From: Martyn White
Sent: 13 August 2019 13:55
To: Planning.Responses <Planning.Responses@arun.gov.uk>
Cc: Zac Denton <Zac.Denton@arun.gov.uk>
Subject: R/164/19/L

R/164/19/L

The application relates to a number of proposals which are required in order to ensure that the current health-based use can remain. These proposals all appear to have been carefully considered in order to ensure that the character and significance of the building is not harmed. In fact, the replacement of the inappropriate windows will be an enhancement.

GREY ASSOCIATES			
67 RODNEY ROAD WALTON ON THAMES KT12 2LG			
T: 07957 810940 E: INFO@GREYASSOCIATES.CO.UK			
CLIENT	ABBOTS LODGE DENTAL PRACTICE		
TITLE	85 THE STREET, RUSTINGTON, BN16 3NL		
DRAWING	PROPOSED LAYOUT		
DATE	15.04.19	SCALE	1:50
DRAWING No.	ALDP_PS_011_19		
REVISION

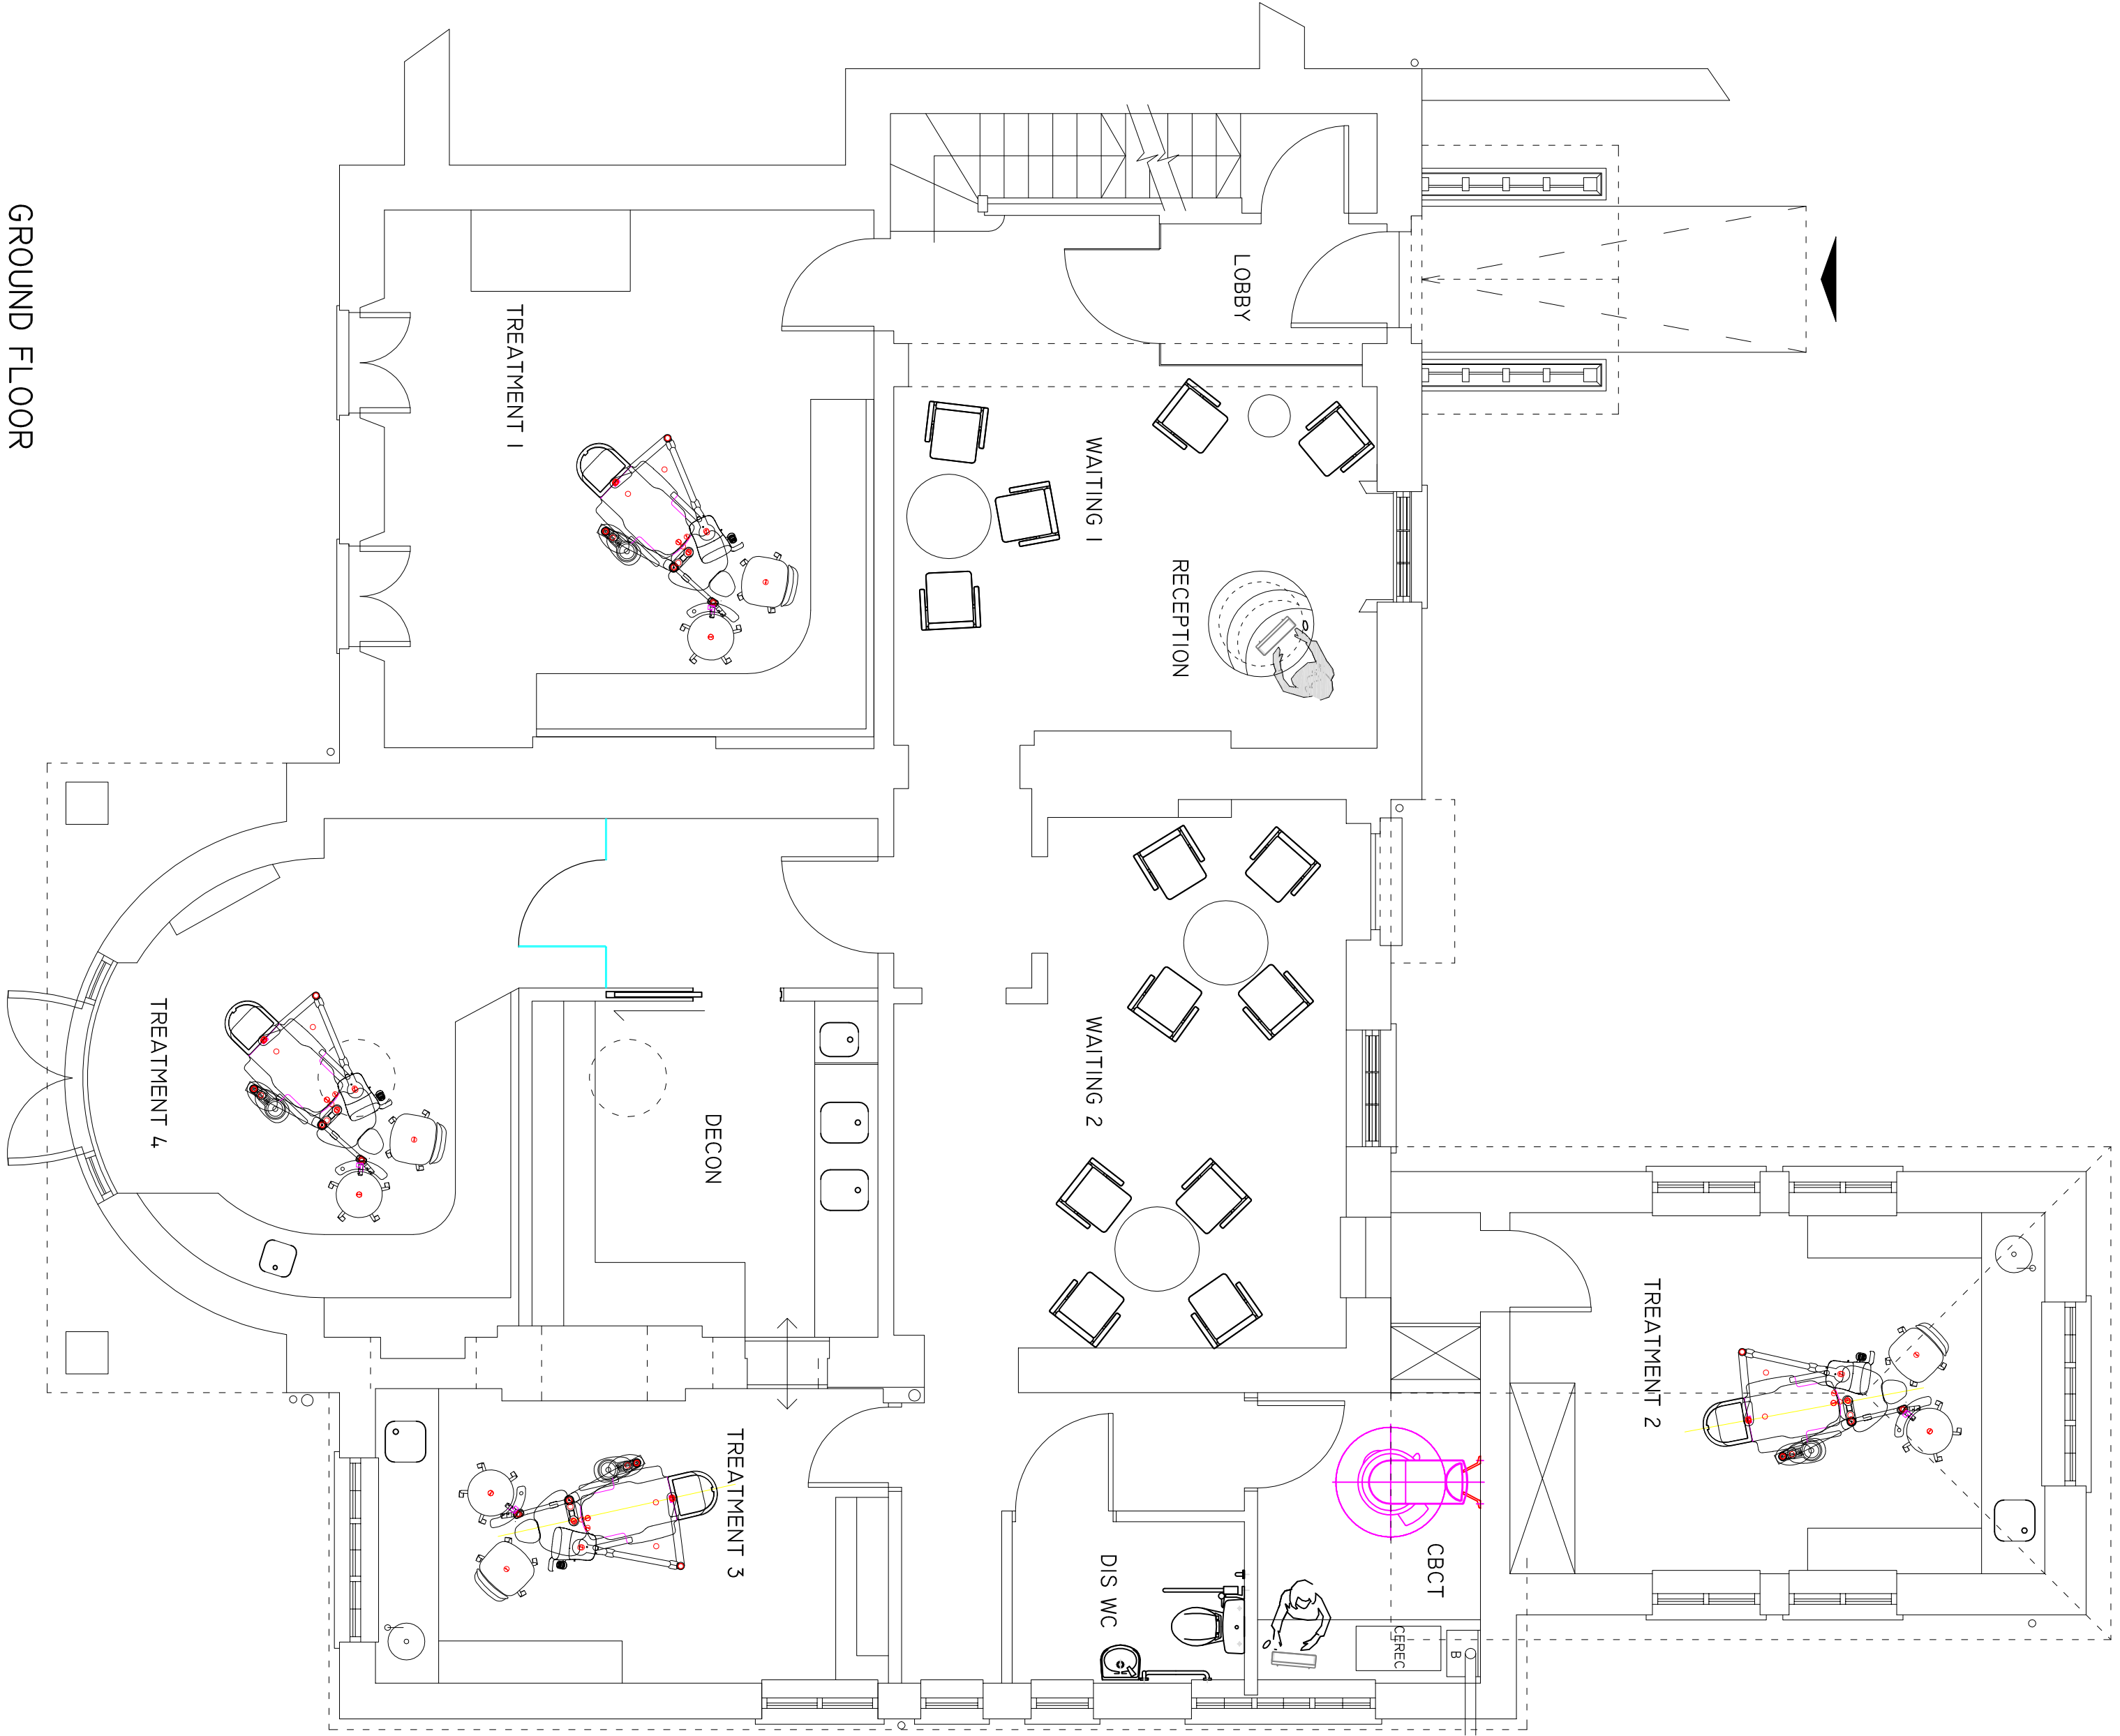
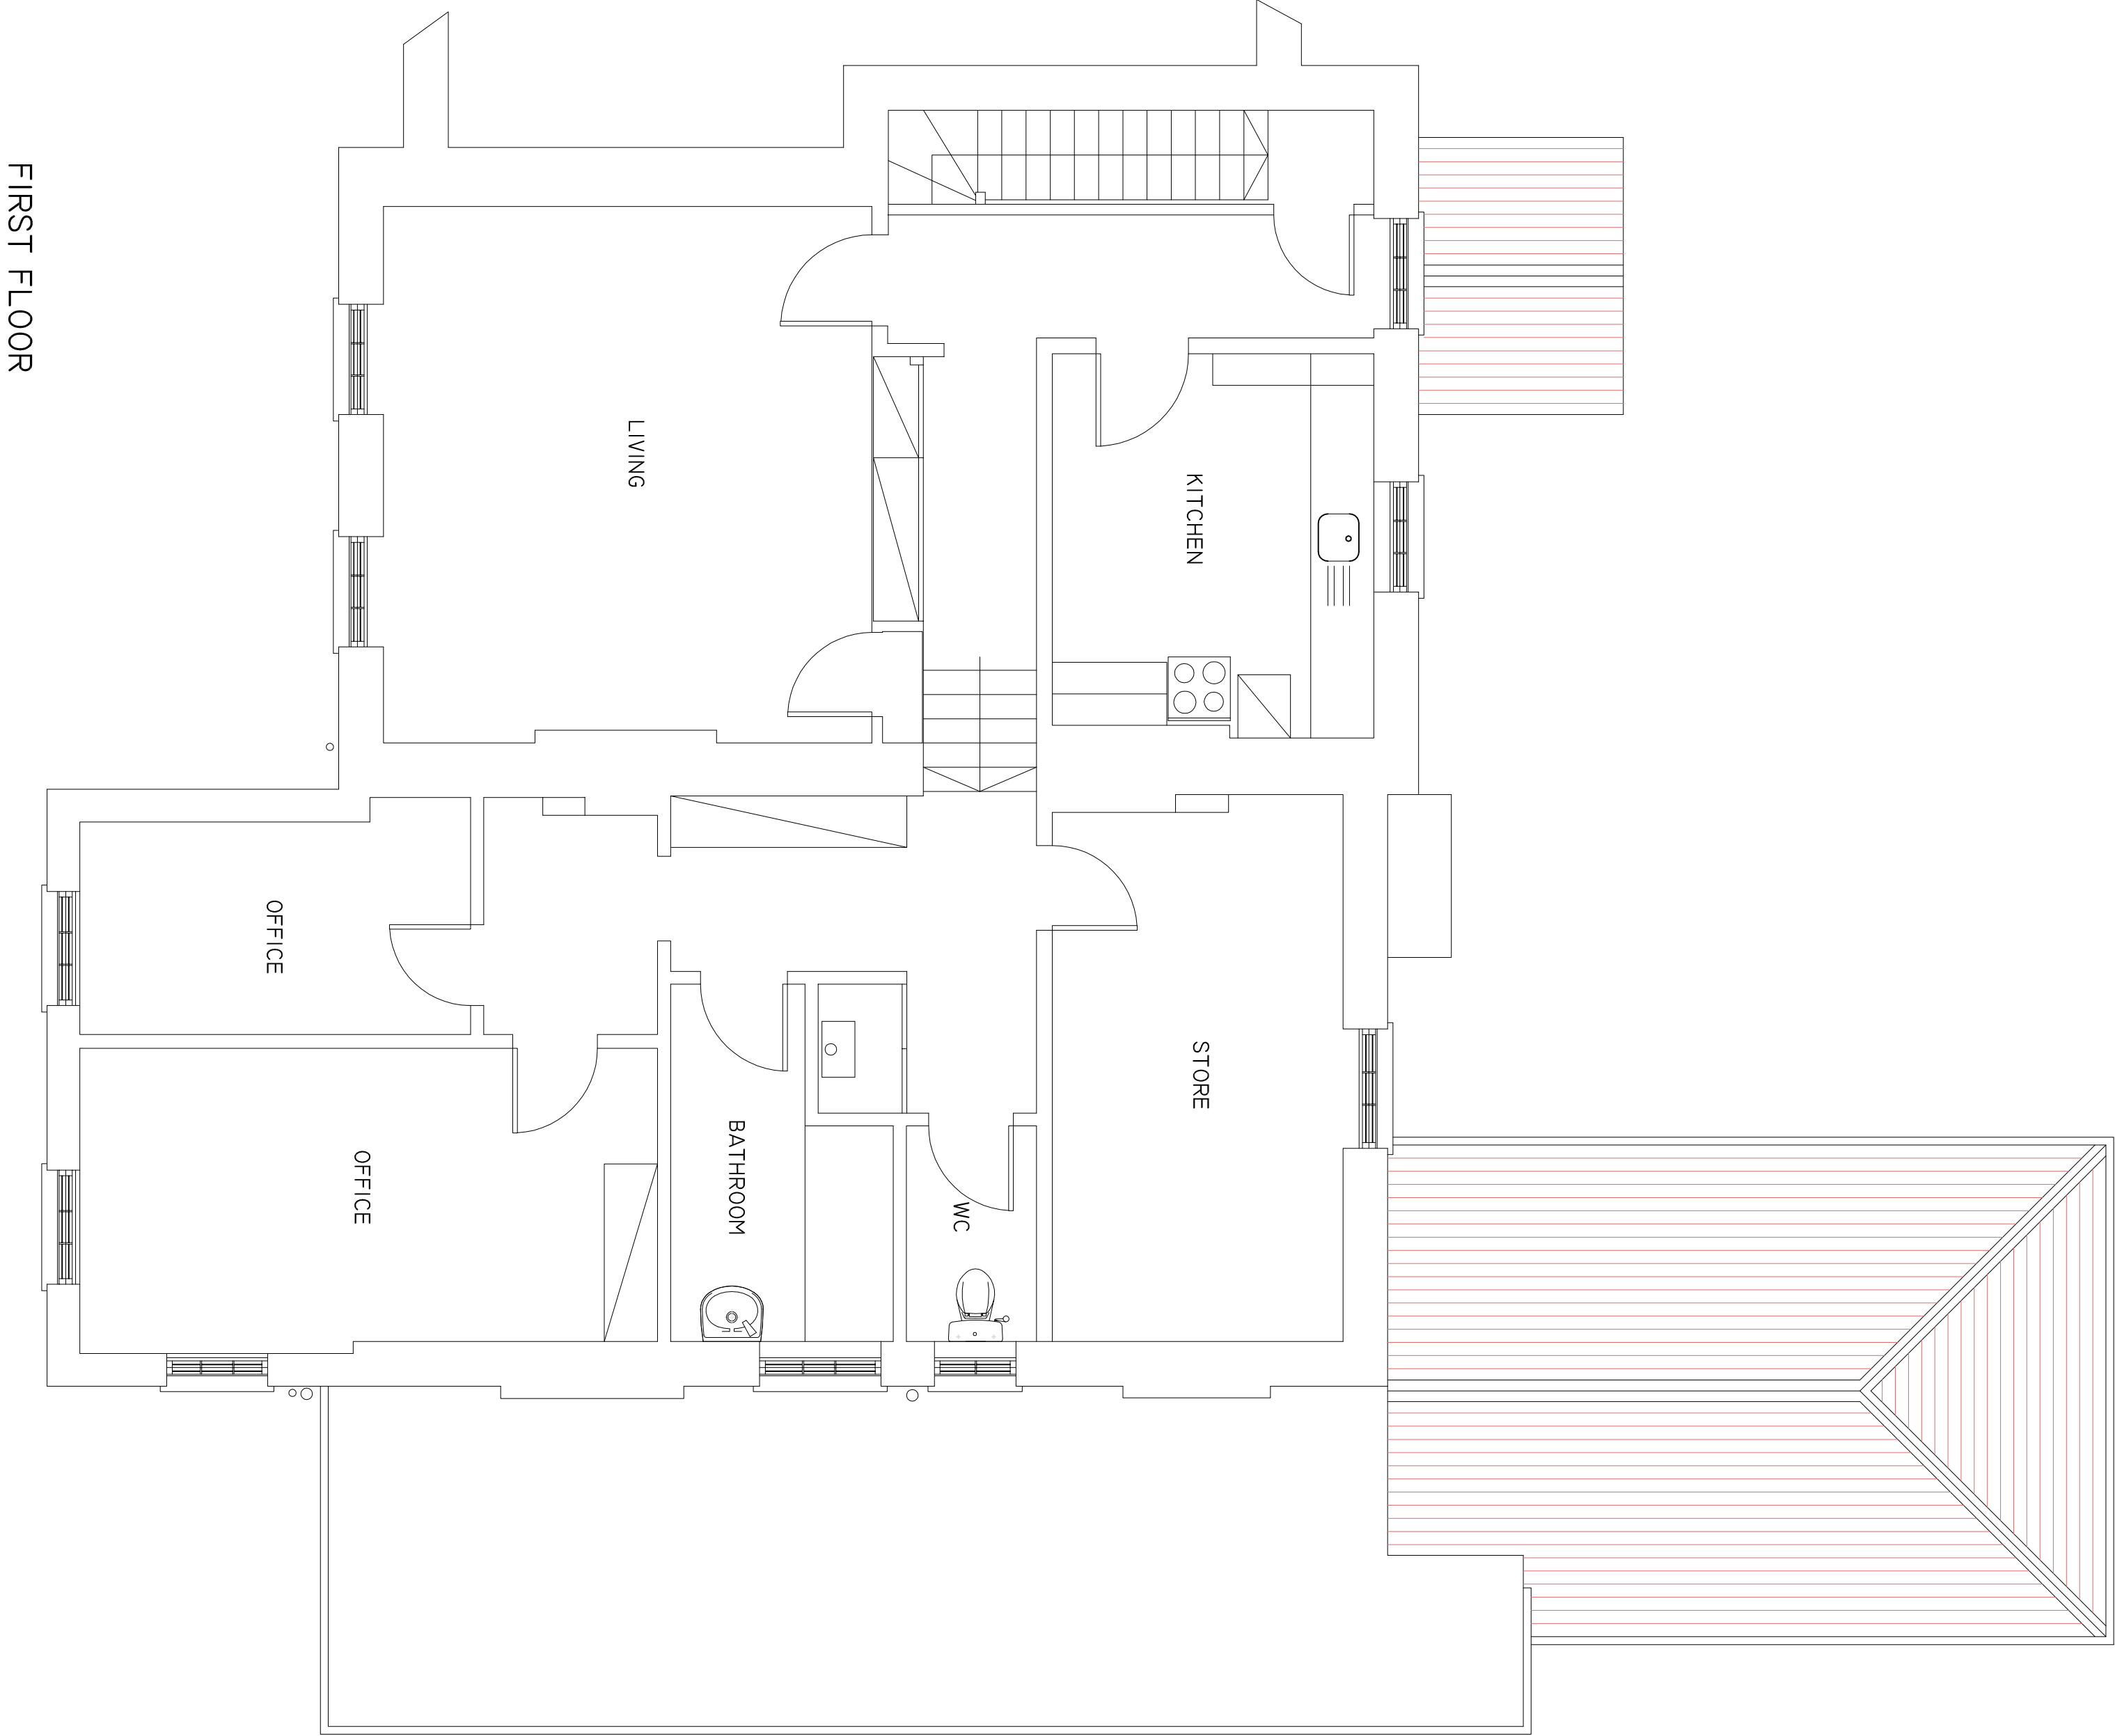
I note that reference is made on the plans to the statement 'investigate the glazed screen detail over the door' to the proposed waiting room number two. Whilst this action is considered to be acceptable, it is recommended that the applicant keep the LPA informed of any discoveries made, and any proposed works that would result.

DRAWING PROPOSED GROUND FLOOR WORKS

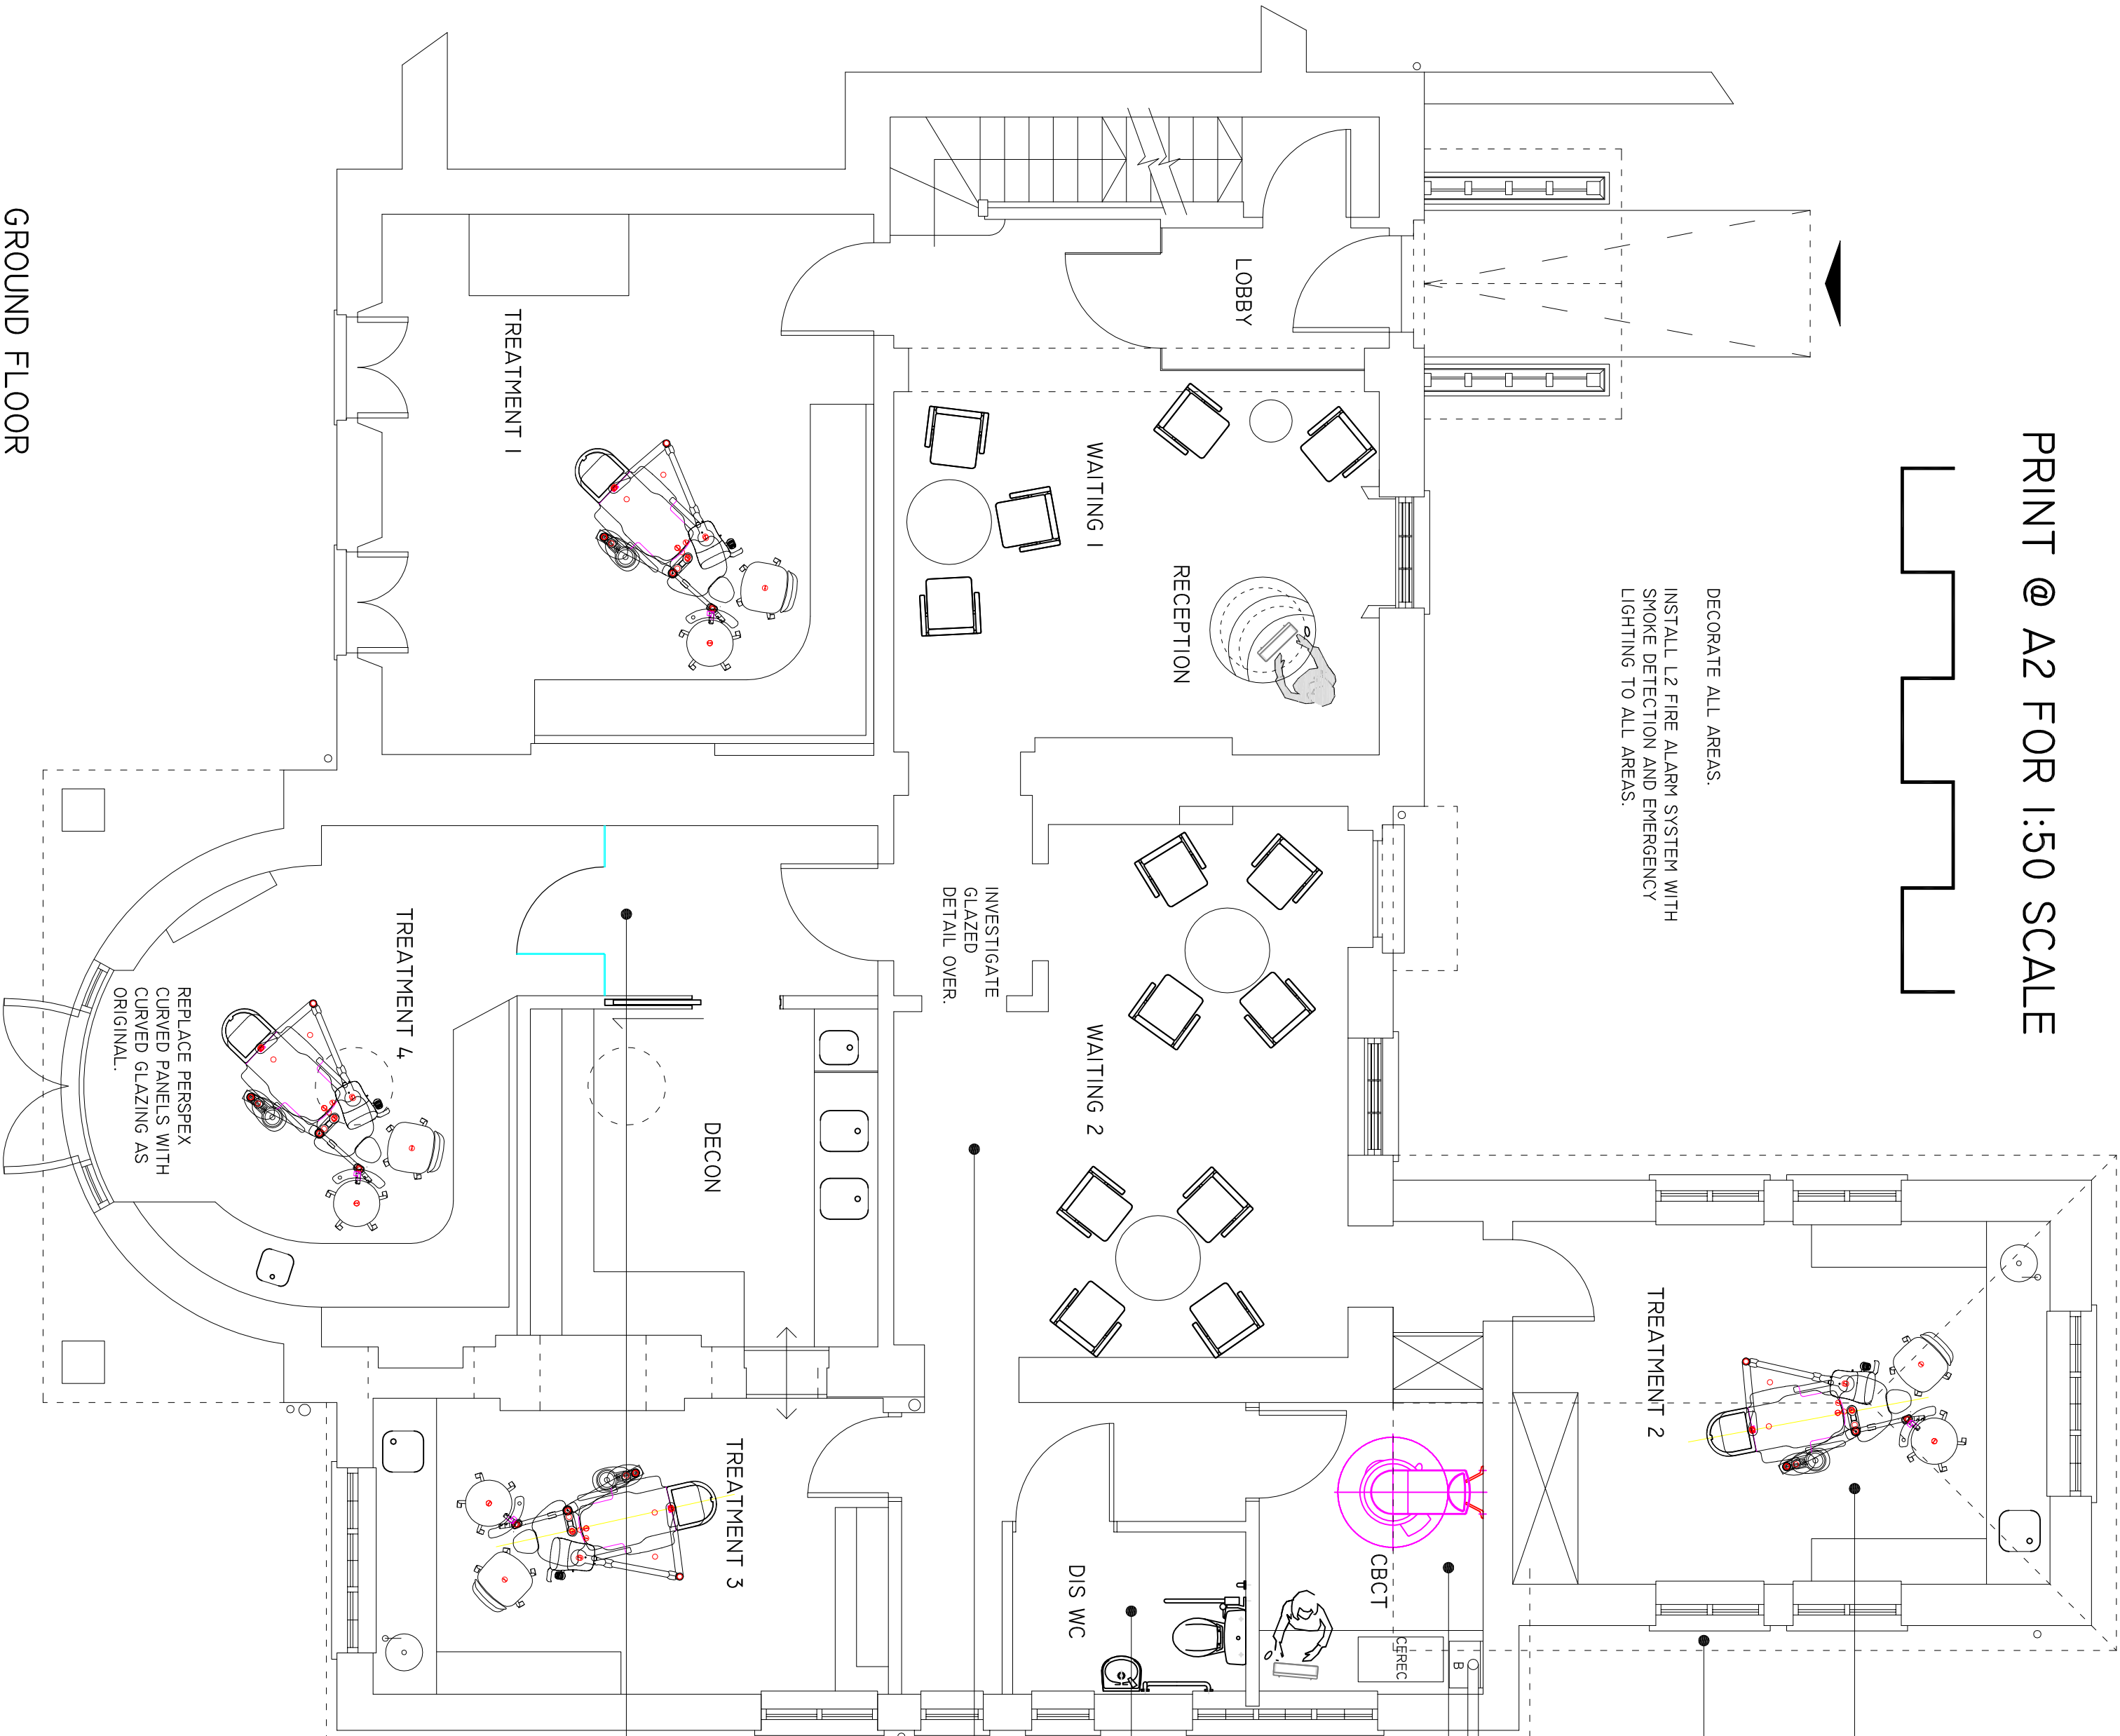
If minded to approve the application, please condition that details related to skirting and mouldings should match those of the existing, traditional features. Further, details of the replacement windows, the new glazed screen door to treatment room 4, and details of any new doors should be provided for by way of condition.
